# SDRP RESPONSE

## State Design Review Panel – 9<sup>th</sup> December – First Review

## State Design Review Panel – 25<sup>th</sup> May 2022 – Second Review

16/06/2022 11:56:10 AM

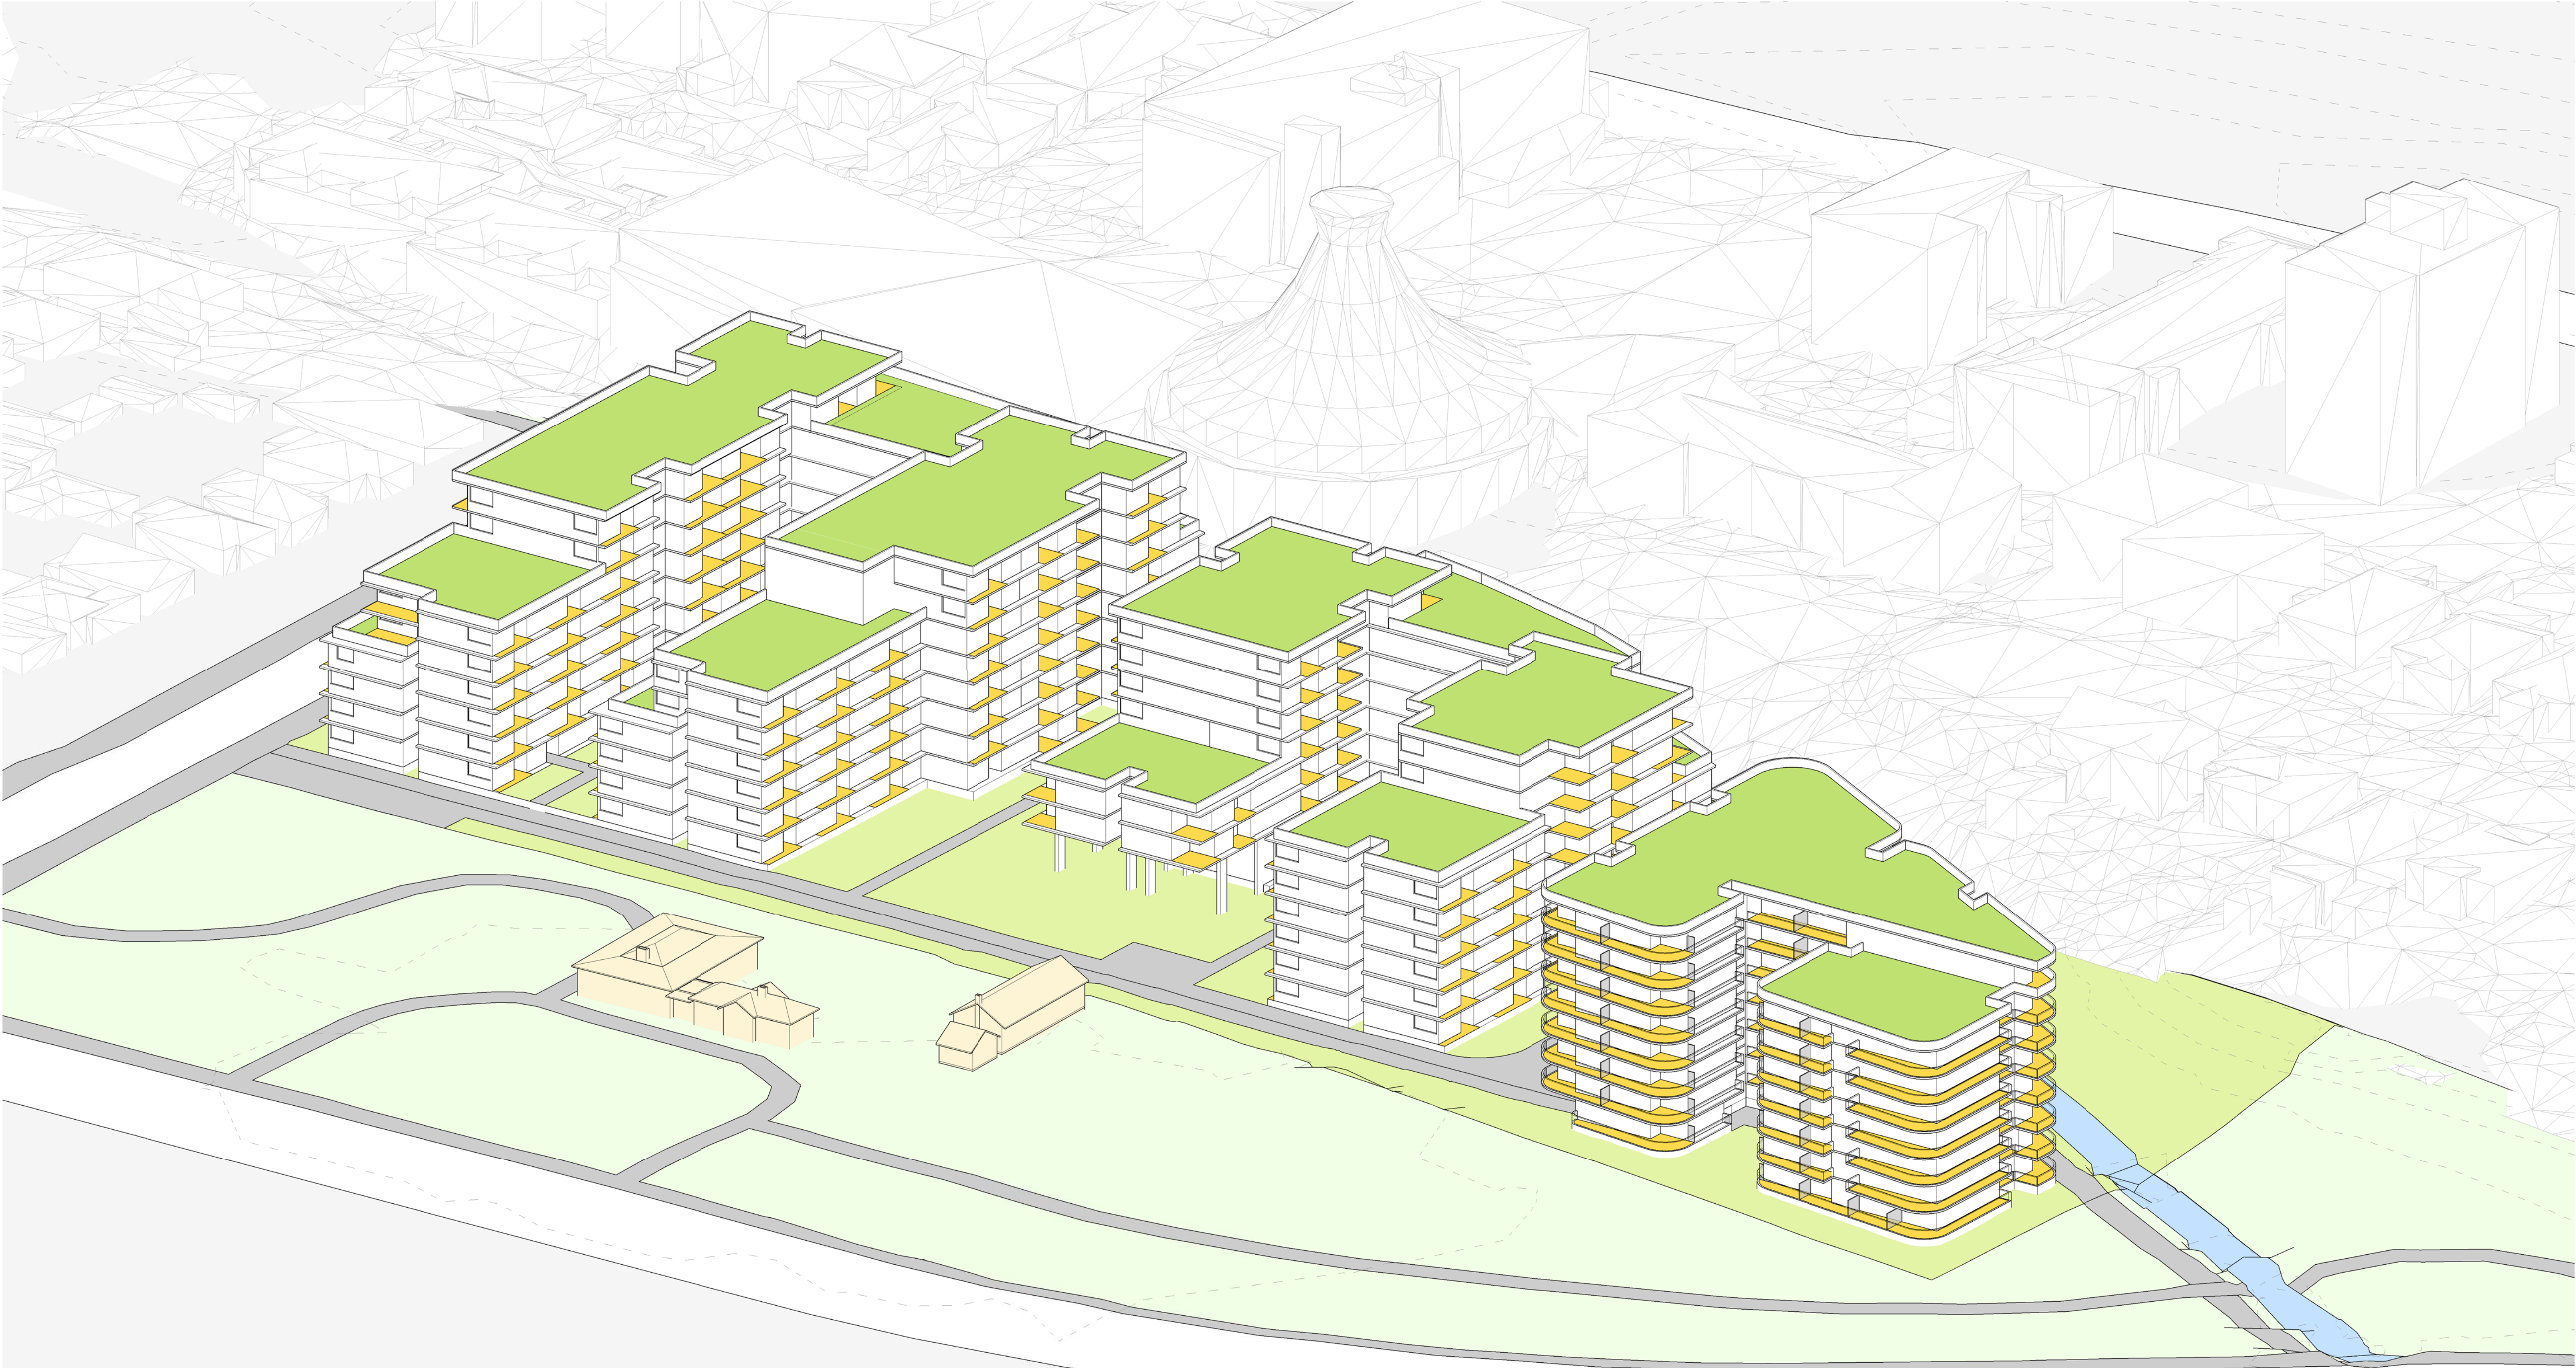
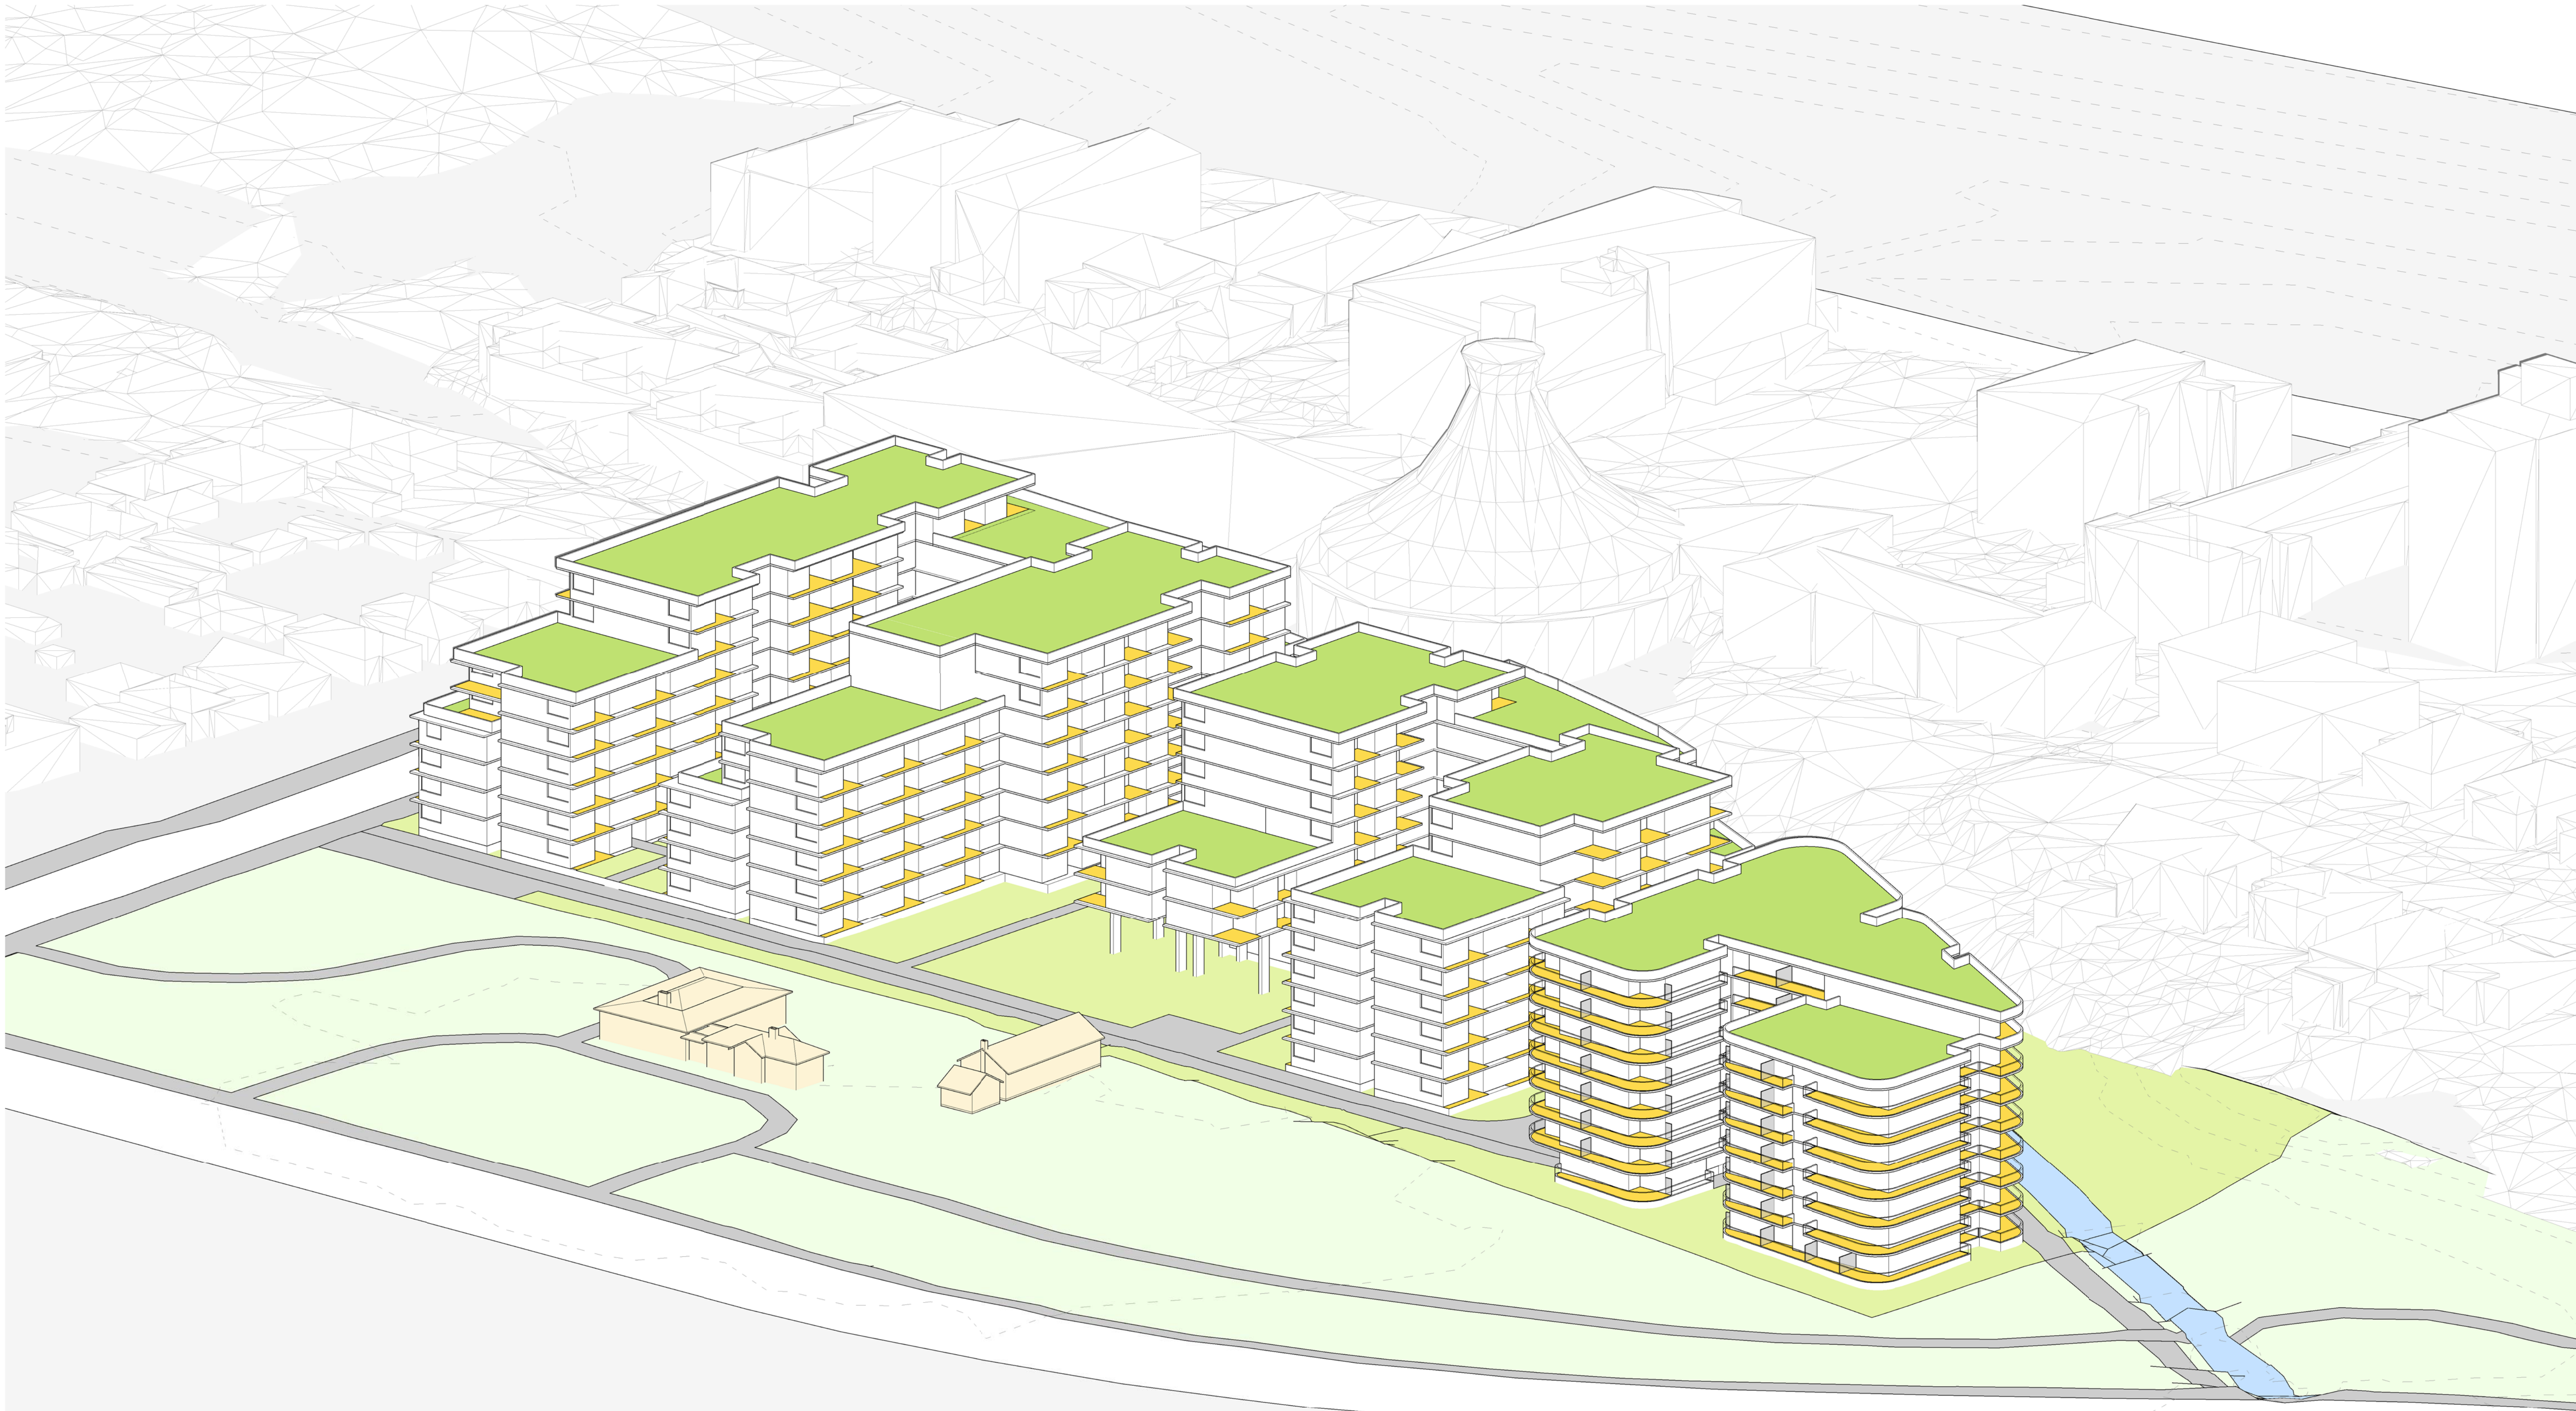
SDRP Comment	Project team's response
	<p>The sun eye view diagrams illustrate that at mid-winter:</p> <ul style="list-style-type: none"> <li>• Passage 1 receives direct sunlight between 9.30am to 2.00pm.</li> <li>• Passage 2 received direct sunlight between 10.15am to 1.30pm.</li> </ul> <p>The benefit of locating taller buildings along the stormwater channel is that the publicly accessible pathways and communal courtyards to the north of site receive direct sunlight throughout the day at the winter solstice.</p> <p>The Landscape Concept Plan prepared Taylor Brammer Landscape Architects includes detailed cross sections through the channel walk to describe the spatial characteristics and includes indicative planting palette illustrating that the natural light levels achieved can sustain healthy growth of planting which supports the vision for the site to rejuvenate the blighted industrial land and to better Connect with Country.</p>

SDRP comment		Project team's response
c	<i>Undertake sun eye view analysis as part of the resolution of the private and public open spaces including along the creek corridor to ensure they receive adequate natural light all year round.</i>	<p>The architectural drawings prepared by Stanisic Architects incorporate a sun eye view and shadow diagram analysis of the proposal to confirm the impact of the proposed built form and to understand the direct sunlight achieved to the Channel Walk at the winter solstice.</p> <p>Refer to SDRP First Review – Response 1.</p>
d	<i>Review the spatial quality and appropriateness of the deep proportions of Courtyard A and relationship with surrounding built form.</i>	<p>The architectural design concept is for 3 x freestanding building forms that are arranged into an orthogonal layout of five fingers that vary in height from 4-8 storeys and adjust to the scale of the existing and future context, including remaining colonial cottages. The built form has been embedded within a parkland setting of courts and passages that creates a framework for permeable pedestrian movement to enable physical and visual connections to the rich cultural landscape setting.</p> <p>The built form has been modified during extensive consultation with the Heritage Council who provided their support for extending the grid of Harris Park onto the site and creating a large open space directly behind Hambledon Cottage to transition from the low-rise cottage to the taller forms along the stormwater channel and interpret the location of Neale's Cottage that once stood on the site. A key guiding principle from a heritage perspective was to achieve a large open space behind the cottage that provides a clear spatial transition between properties.</p> <p>Building A is a u-shaped building with heights that vary from 6-8 storeys with significant modulation within the internal courtyard space that reduces the length of walls and creates a number of spaces within the north facing courtyard. As a consequence, Building A achieves very different characteristics to Building B + C which is desirable and has been encouraged by the SDRP.</p> <p>The Concept Envelope has been modulated to achieve a high level of amenity for occupants as well as ensuring compatibility with the surrounding context. There is no need or basis to further "break down" the floor plates or "reduce their size" as the key guidelines of the Apartment Design Guide (solar access, natural cross ventilation, deep soil, communal open space and building separation) are all achieved and in most cases greatly exceeded.</p>
